**Re: Presbyterian Hospital Parking Garage,
300 Cedar Street SE, (K-15/D022A)
Approval of Permanent Certificate of Occupancy (C.O.)
Certification dated 10/24/07**

**Re: Presbyterian Hospital Parking Garage Conceptual Grading and Utility Plan
Engineer's Stamp dated 5-10-06 (K15/D22A)**

Re: Presbyterian Hospital Parking Garage, Engineer's Stamp dated 8-22-06
Request for Building Permit Approval, (K15/D22A)

Re: Presbyterian Hospital Parking Garage, No Engineer's Stamp, (K15/D22A)

SKC-002

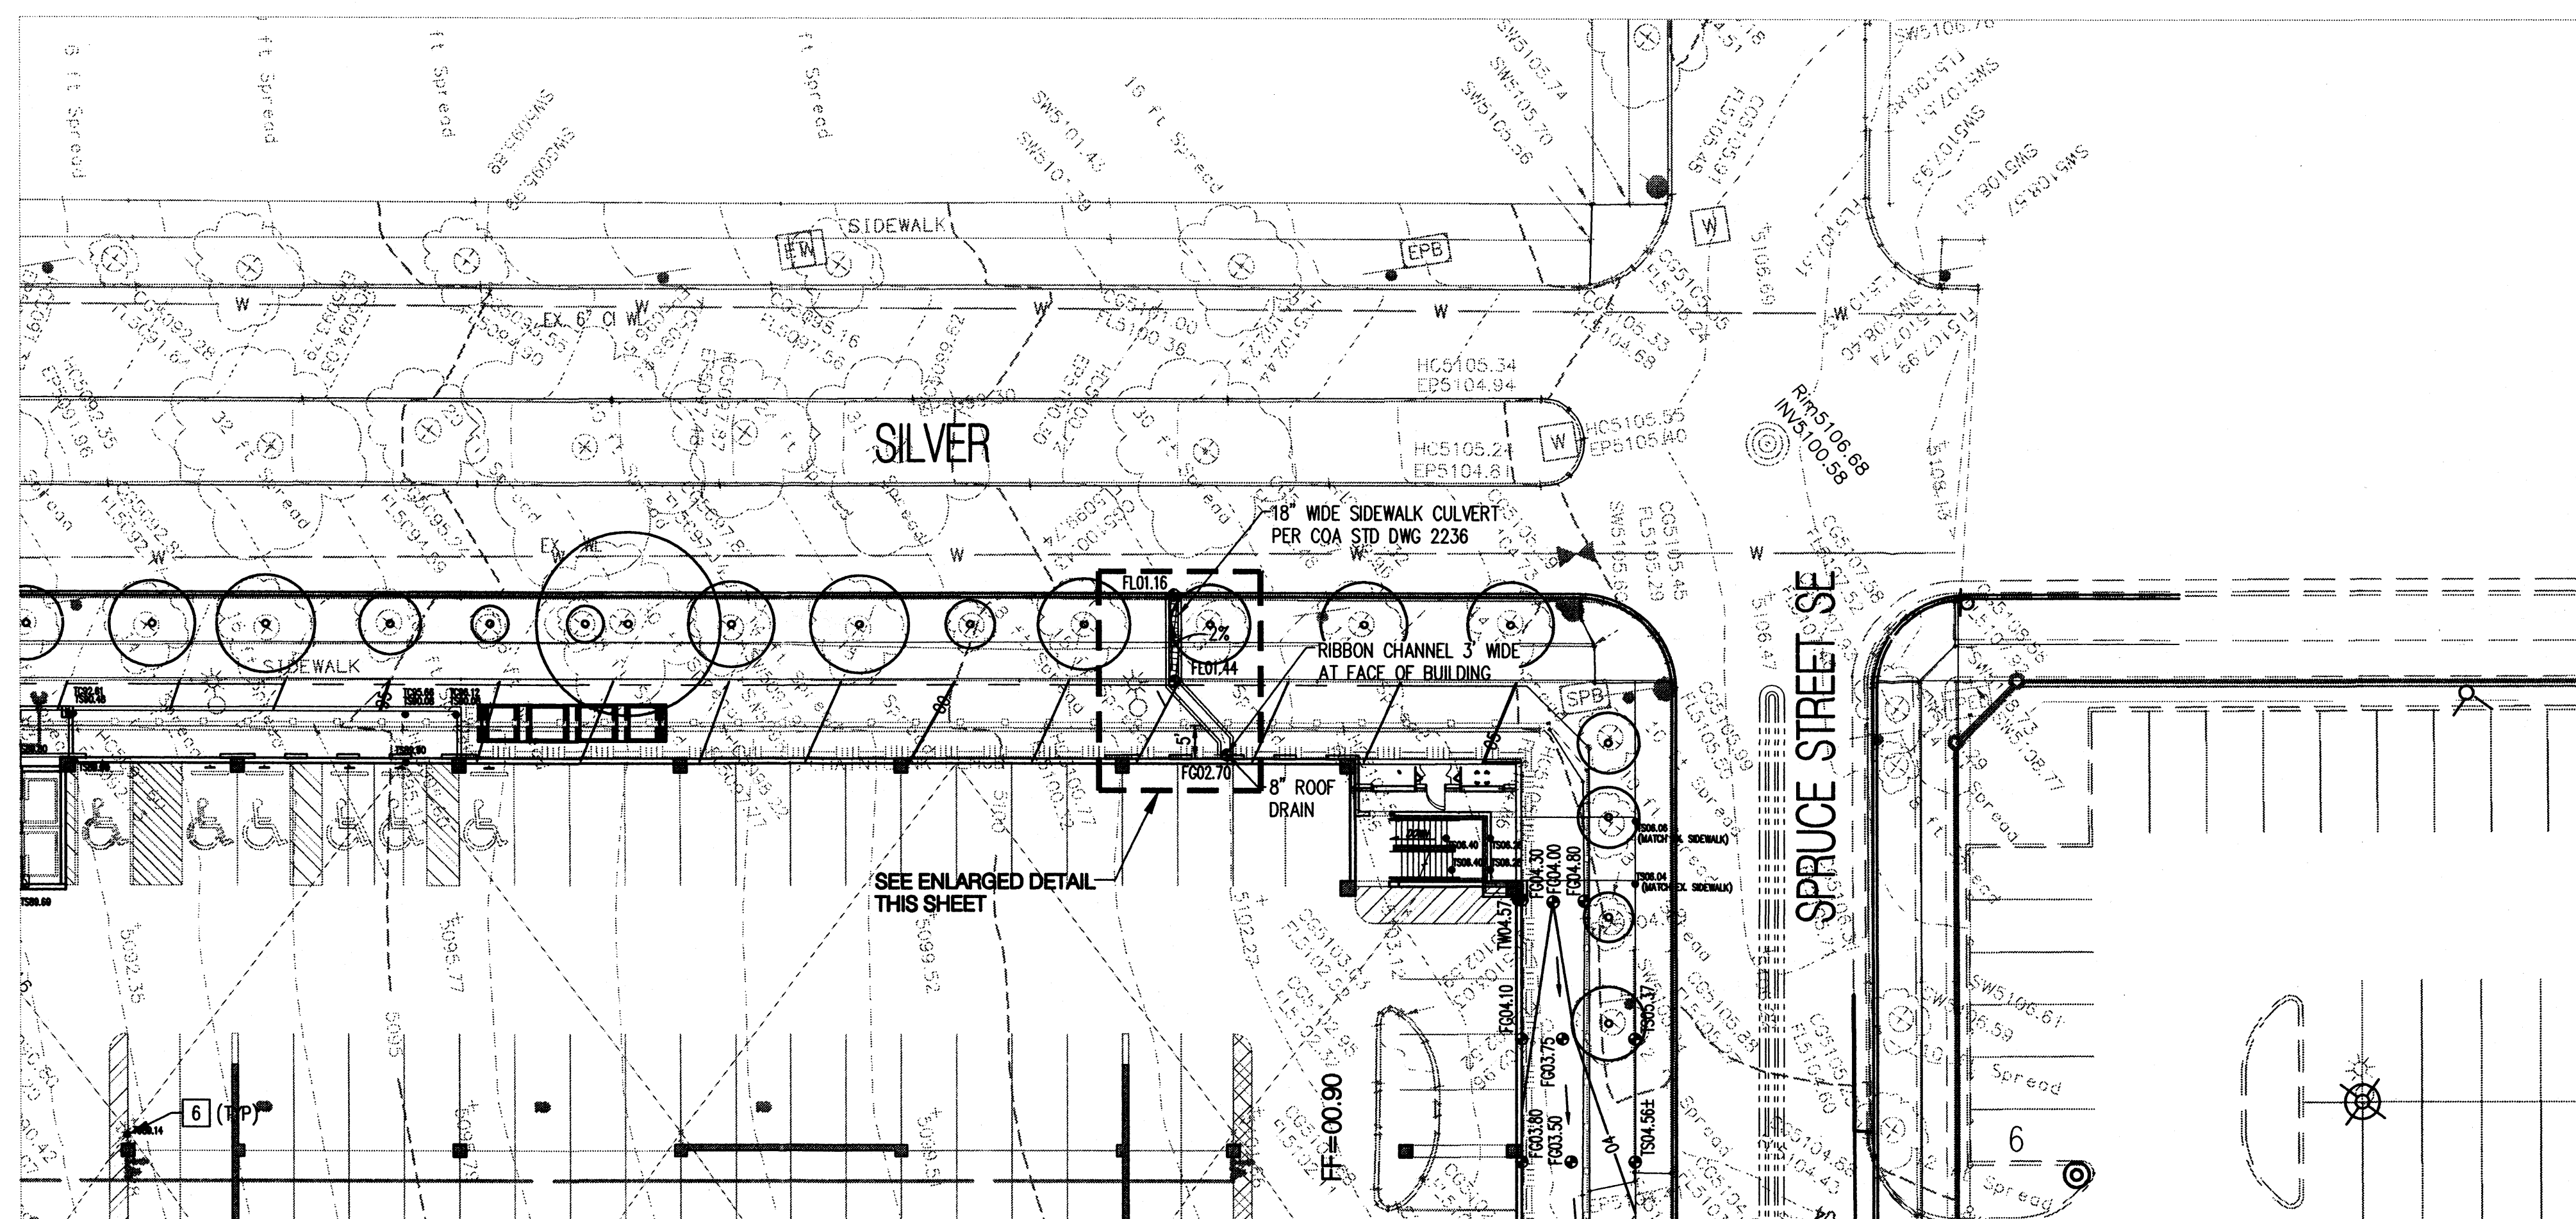
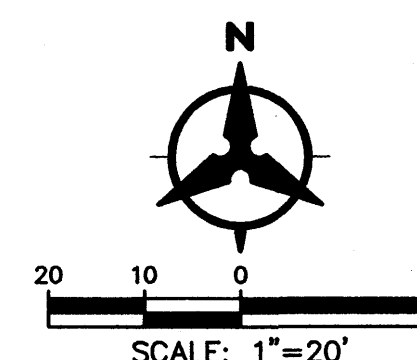
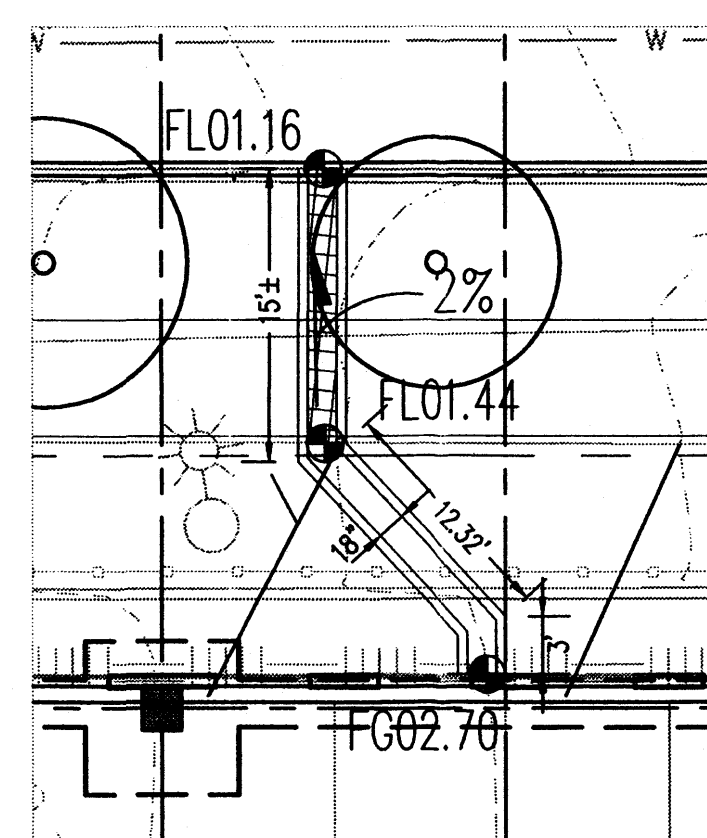
- The sidewalk culvert geometry must be revised such that the flow line is orthogonal to the Silver Ave. right-of-way.
- A signature block must be included for the drainage inspector.
- The standard SO-19 construction notes must be included on the plan drawings.
- The plan must be stamped, signed, and dated.
- Please resubmit the plan on a standard 24" x 36" plan sheet.

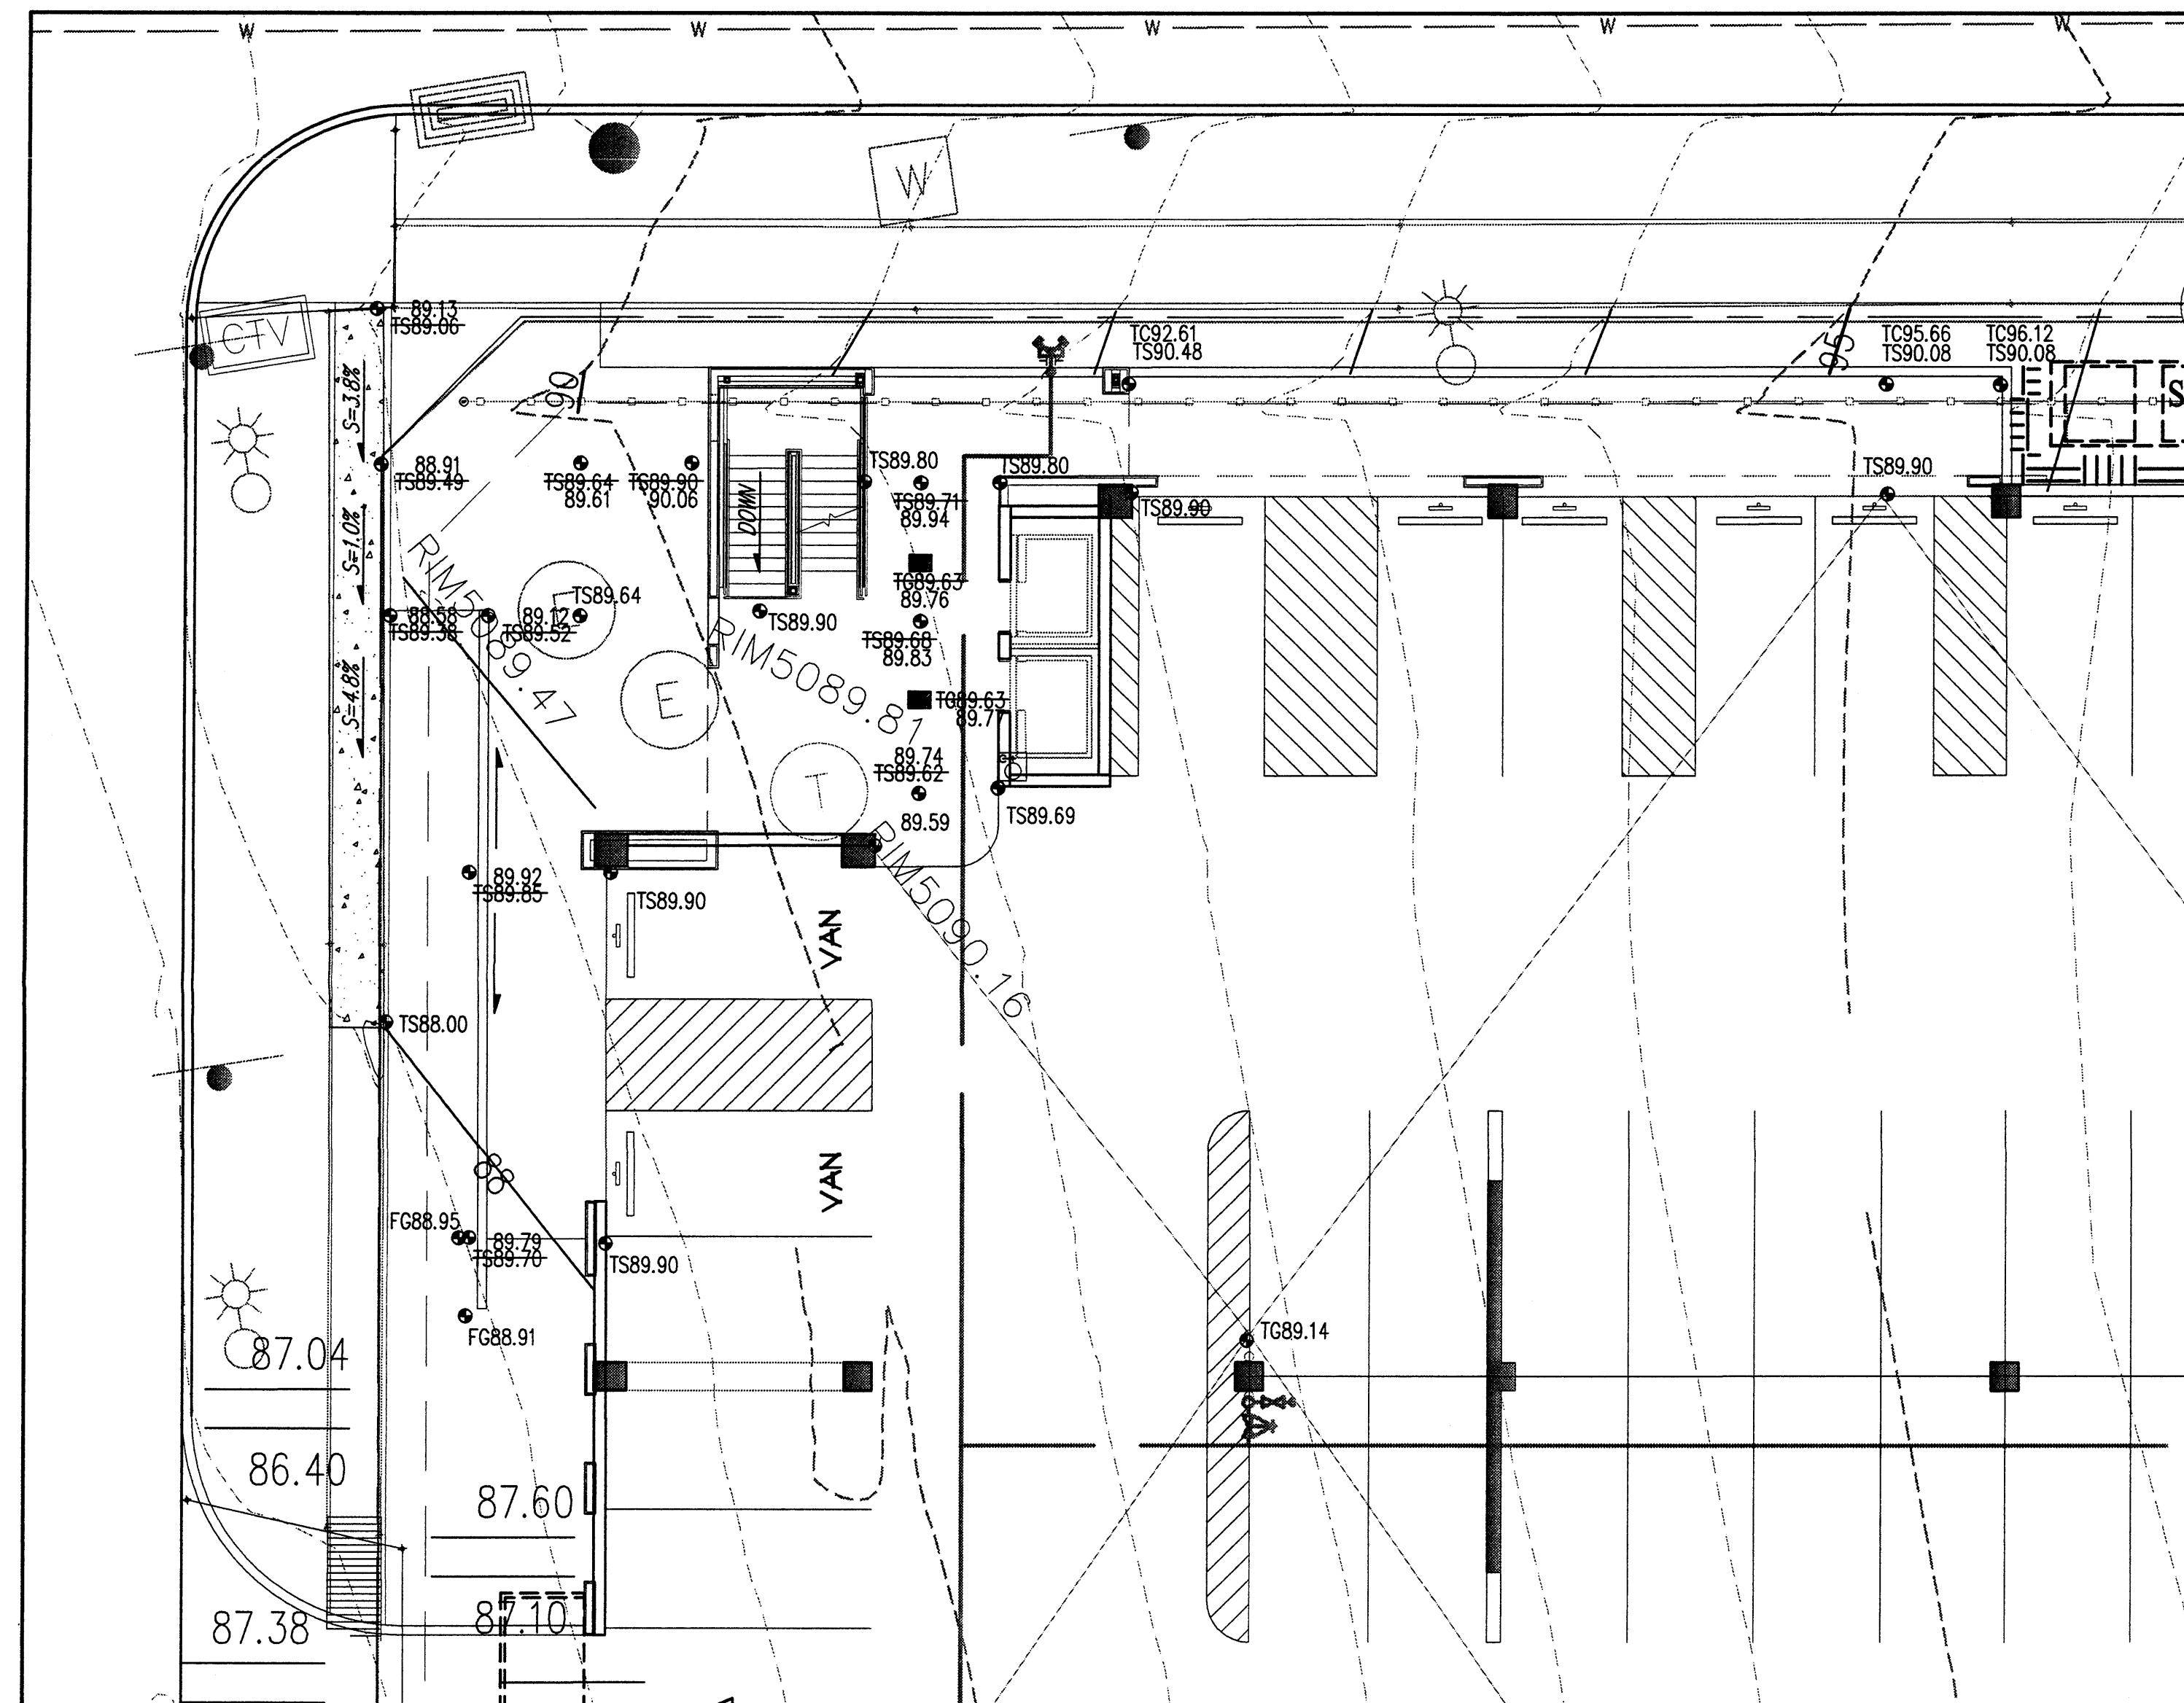
- Please include the proper legal description and a zone atlas page with the project site highlighted.
- Demolition notes 3 and 4 both point to the sidewalk culvert at the southwest corner of the site. Is this to remain or be removed? An undefined symbol is also shown at this location. Is this a light pole and will it need to be removed / relocated as part of the site work?

- The SO-19 notes need to be revised to reference New Mexico One Call at 260-1990 for the line spots.
- Please define the extents of the sidewalk removal and replacement at the southwest corner of the site in a similar fashion as was shown at the northwest corner. Also define the associated symbology on the legend.

- Grading note 2 is utilized at the Spruce entrance but no sidewalk culvert is shown. Based on the drainage narrative, this appears to be a typographical error. If this is intended to represent sidewalk removal and replacement, please define the extents and modify the construction notes accordingly.

- Do the area drains (general note 6) outfall to the sanitary sewer or the sidewalk culvert(s)? Please address this in the narrative.
